Project: The Sea Link Project

Your Ref: EN020026

National Grid (Sea Link) Development Consent Order (Application Reference: EN020026)

Written Representation of the Historic Buildings and Monuments Commission for England (Historic England)

Document 9.3.3 Suffolk Section Phase 2B Archaeological Evaluation Report Extract illustrating the location of the henge in relation to the proposed scheme

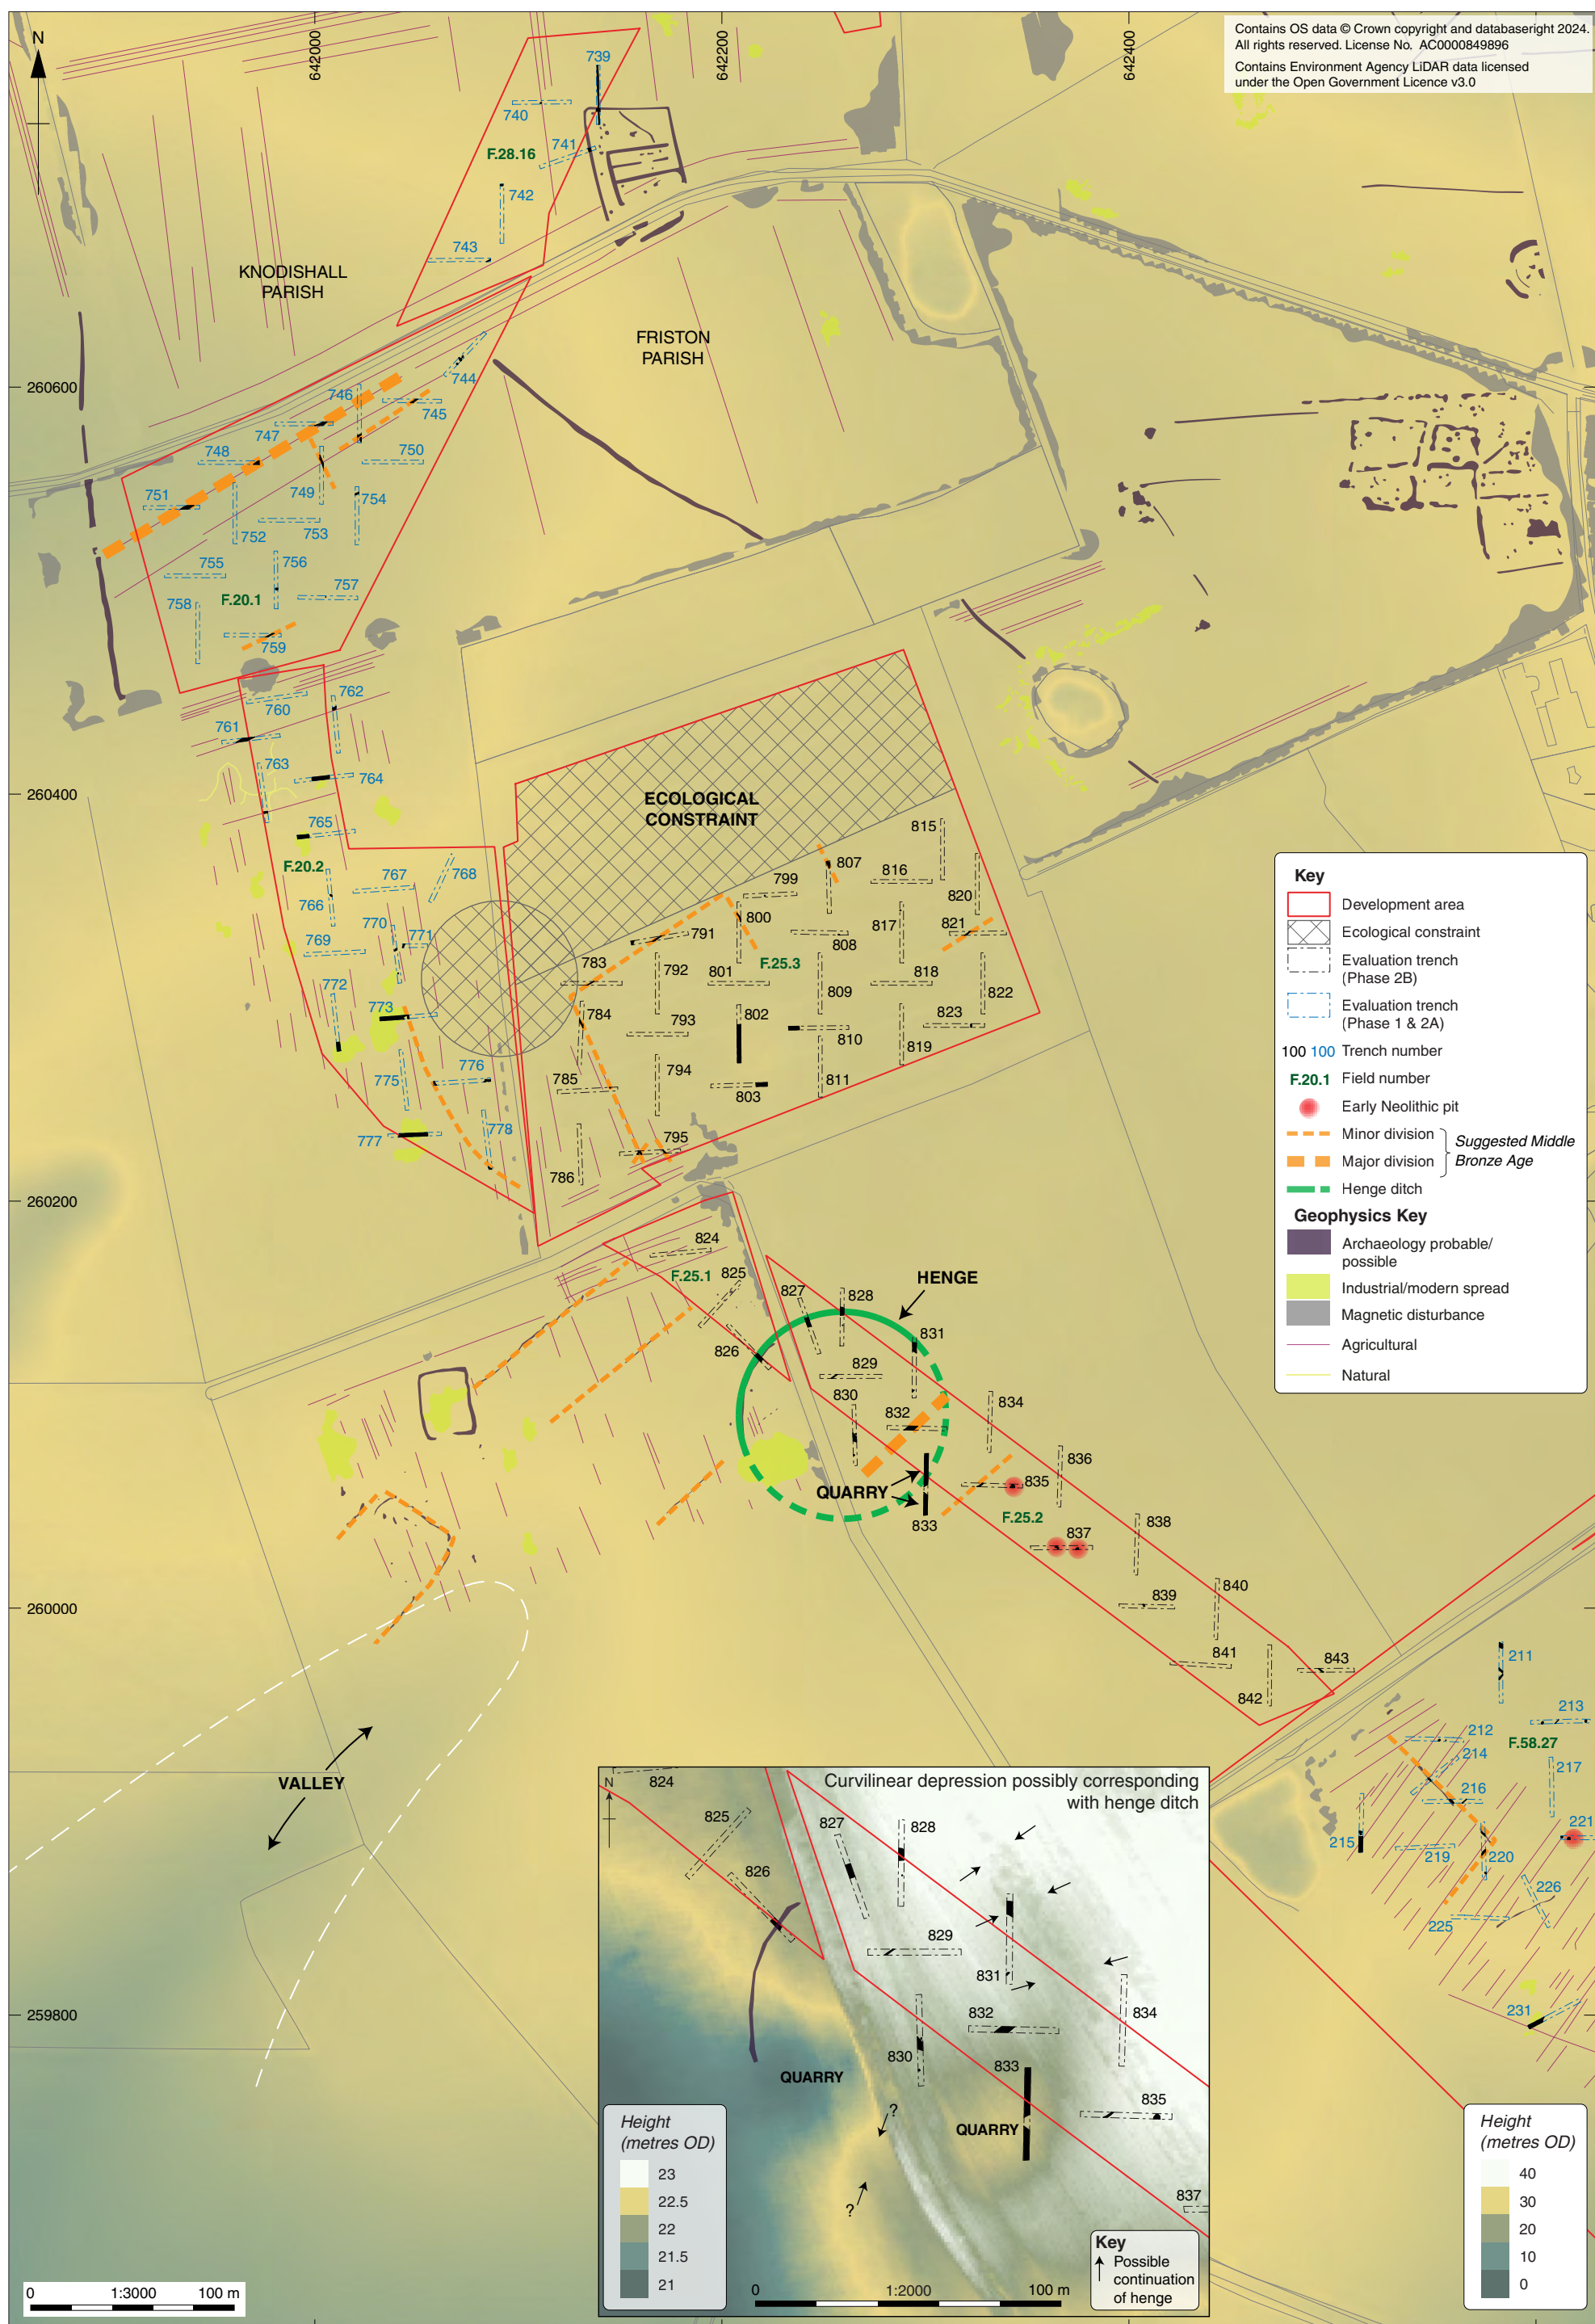
Geophysical Survey report [CR-057] outlines the results of the additional non-intrusive survey work undertaken in the area where phase 2b of trial trench evaluation [AS-136] identified archaeological feature interpreted as a neolithic henge. Geophysical survey of the wider area surrounding the feature provided additional data which allowed better understanding of the remains. The archaeological site was re-interpreted on the basis of its morphology as a G-shaped enclosure of possible Late Bronze Age.

Historic England considers that this re-interpretation is reasonable in light of the new data. The identified archaeological site is a non-designated heritage asset with archaeological interest. It is of likely regional importance, as assessed in an Addendum to Volume 6 Environmental Statement [CR1-055]. The negative effect on this asset resulting from implementation of the Project, depending on the exact mitigation measures, could be significant.

Addendum to Volume 6 Environmental Statement [CR1-055] outlines that two options for mitigation of archaeological remains in the change 3 area are being considered: re-routing of the cable and haul road corridor to the east to avoid impact on the G-shaped enclosure; and archaeological excavation of the entirety of the G-shaped enclosure to allow for the original route of the cable and haul road.
